Flying Horse North Impact Identification

March 14, 2022

Impact Identification Statement_v1.pdf Markup Summary

Site Location

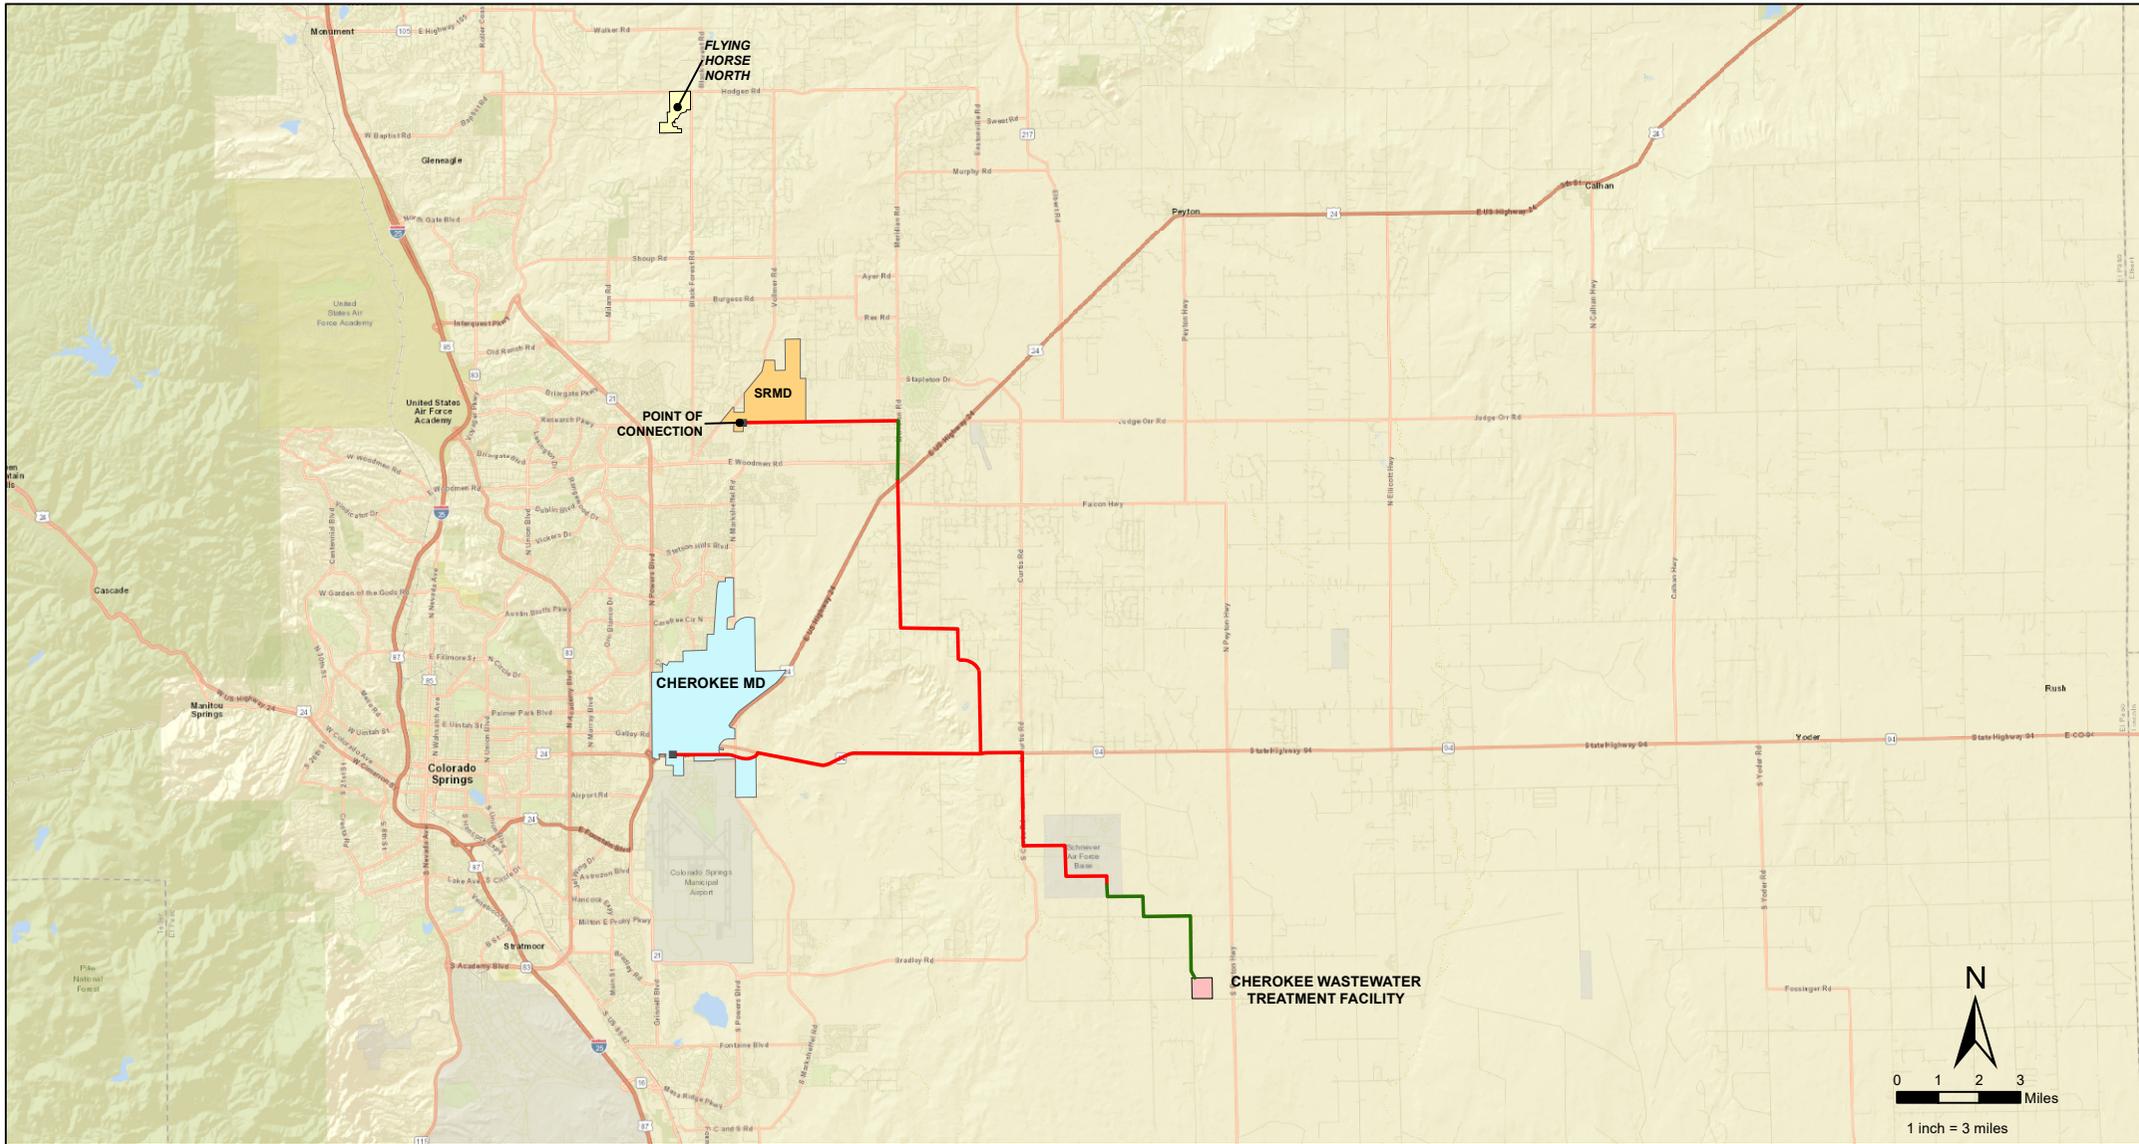
there are jurisdictional dams within FHN. Please consider addressing these features. Staff understands that these were reviewed with the original FHN development and approved by the State Dam.

typo. Please also include the intent for commercial development.
